From: Contact Centre (CRM) <contact@ribblevalley.gov.uk>
Sent: 18 March 2026 14:52
To: Planning
Subject: Planning Application Comments - 3/2026/0021 FS-Case-814561262

Planning Application Reference No.: 3/2026/0021

Address of Development: 41-43 Wellgate
Clitheroe
BB7 1LU

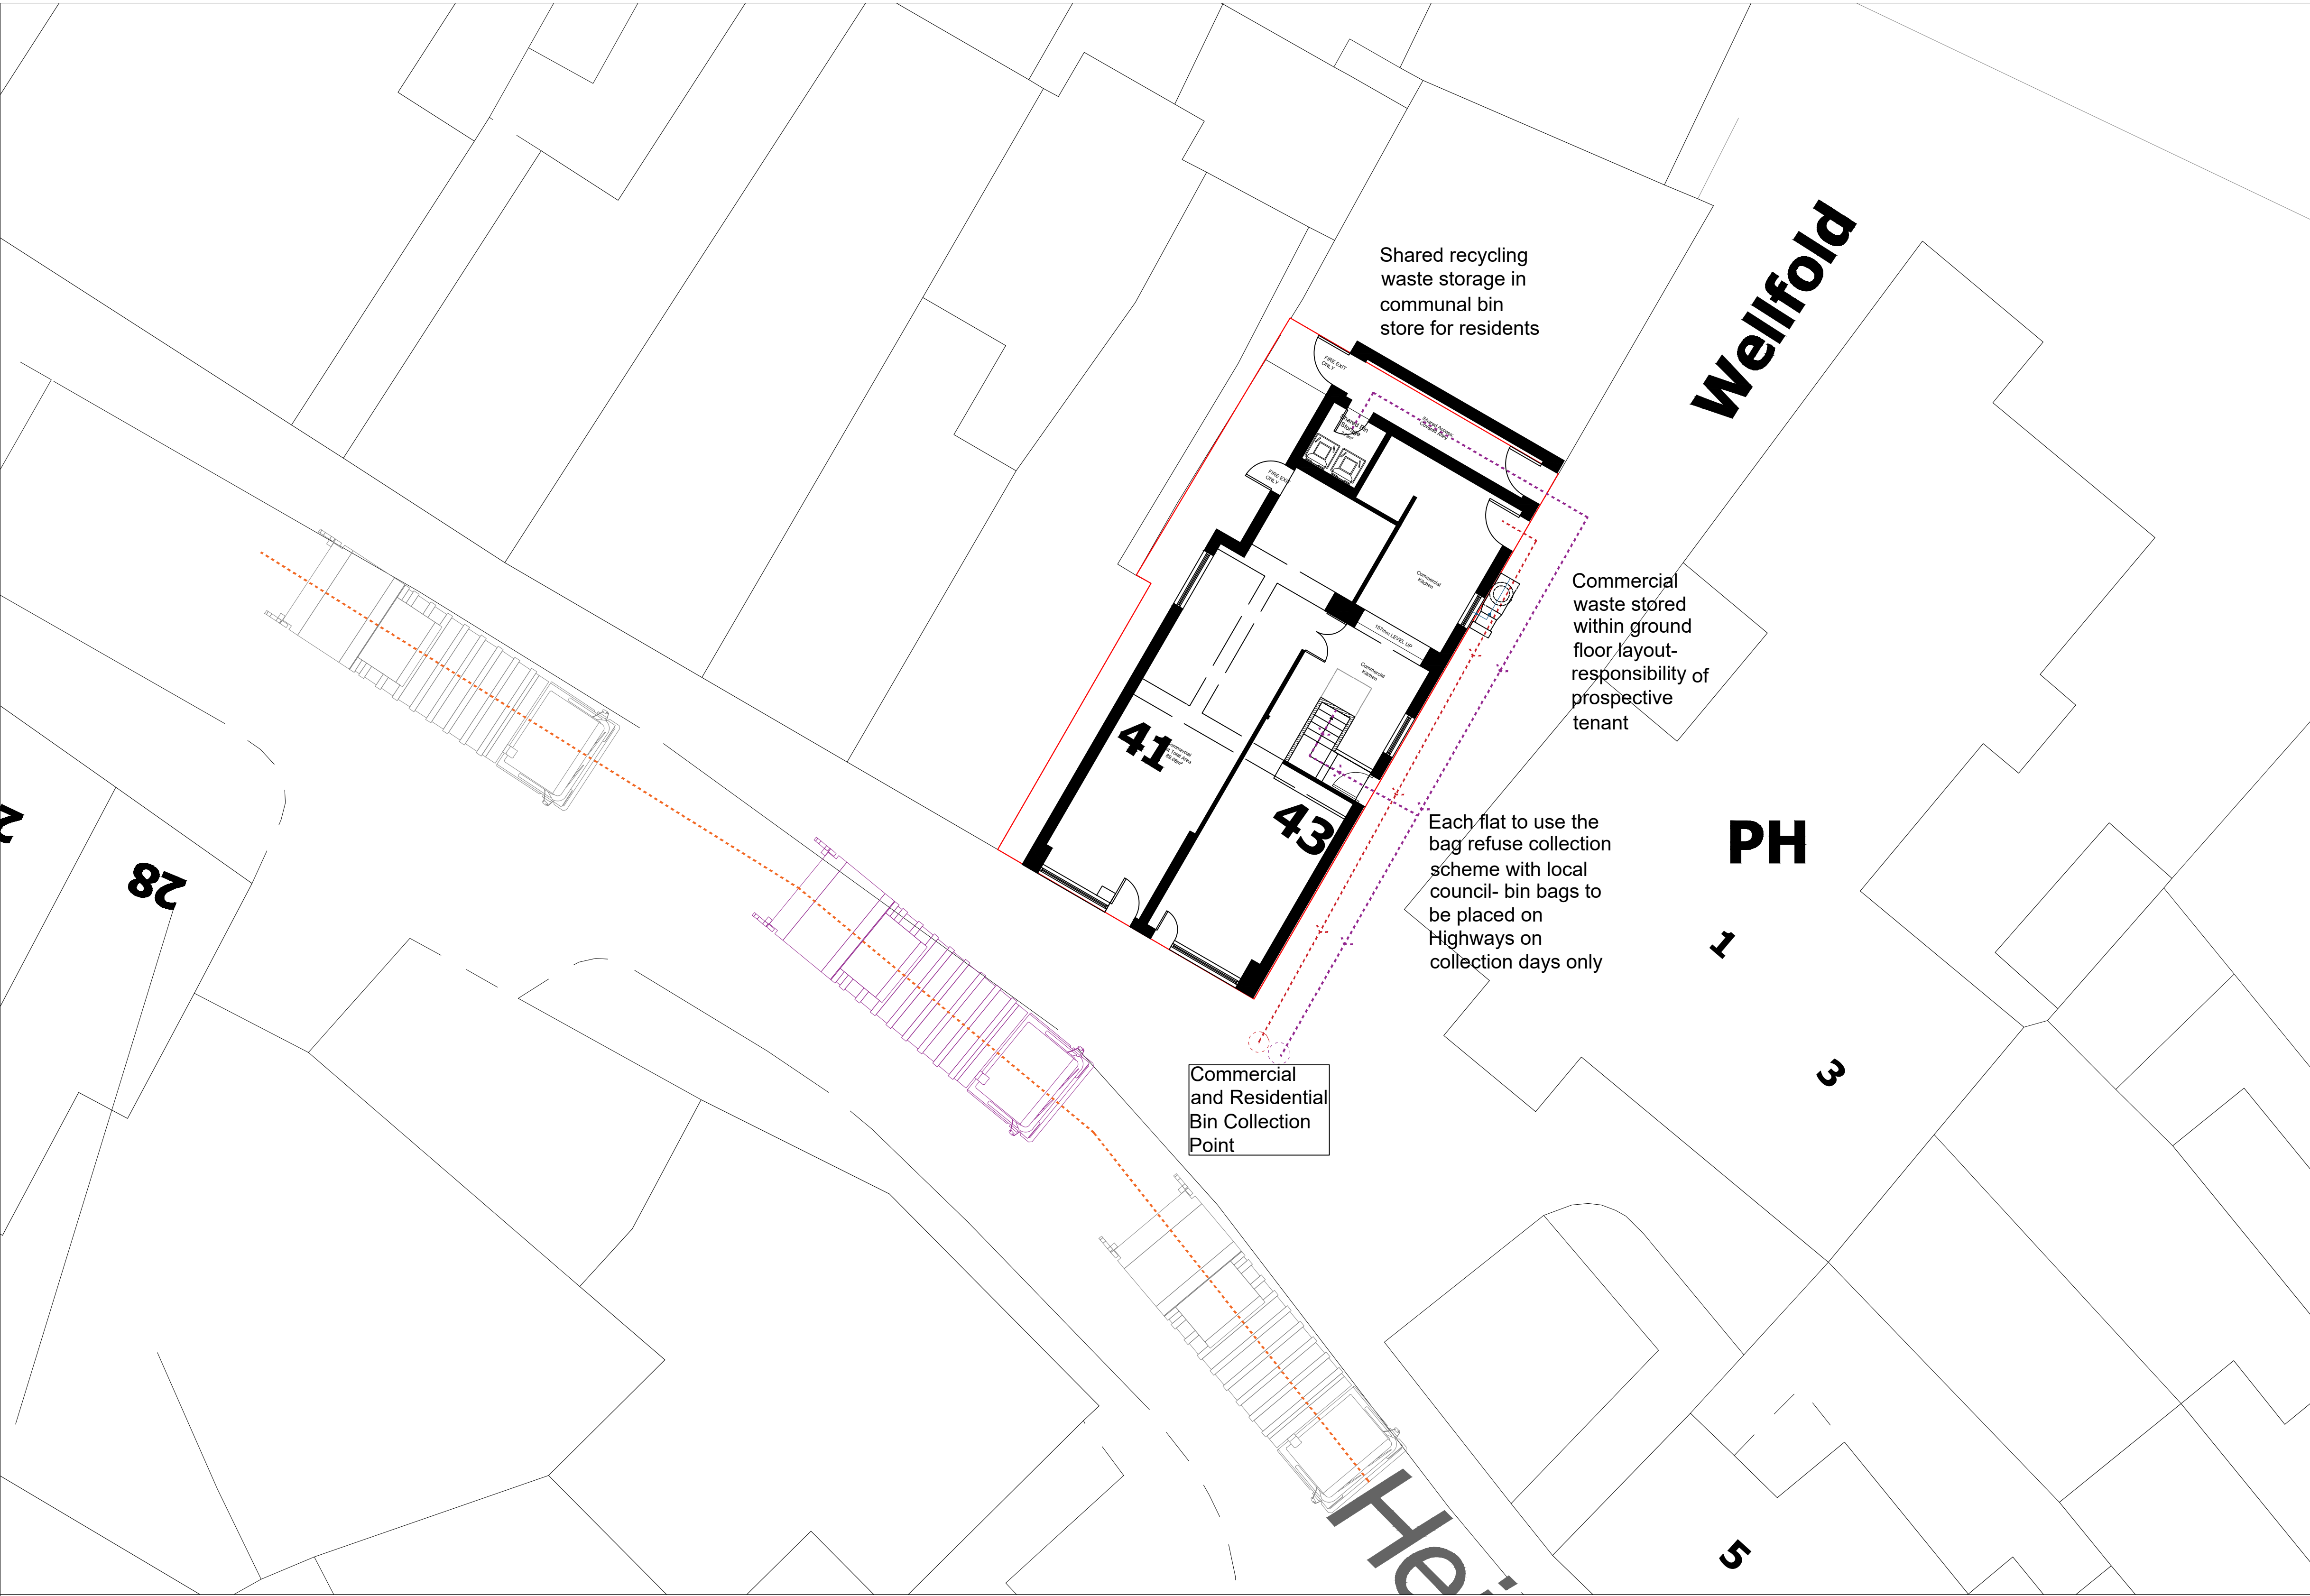
The usual RVBC tickbox for a site refuse plan with one commercial and four residential properties having access to a total of two single bin spaces. Of course, this will not matter as there is no enforcement of previously agreed refuse plans - see [REDACTED] commercial skip causing a dangerous obstruction being abandoned on the pedestrian refuge area of Wellfold without action (despite the planning approved access to shared bin store); now the [REDACTED] also abandons all skips and bins 8-10mts away from the planning approved bin store. Despite Environmental Dept being shown evidence of the litter and actual vermin - no interest or action. I am sure this gives any applicant confidence that there is no need to consider the impact further. The refuse plan on this application suggests bags of rubbish to be left in the dead centre of a private driveway to which none of the residents will have anything other than pedestrian access, but neighbours need 24hr access. That will not end well. It is unclear if this corner of the town is the only central part where rubbish can be left outside at will by commercial and residential properties; now not even in a bin.
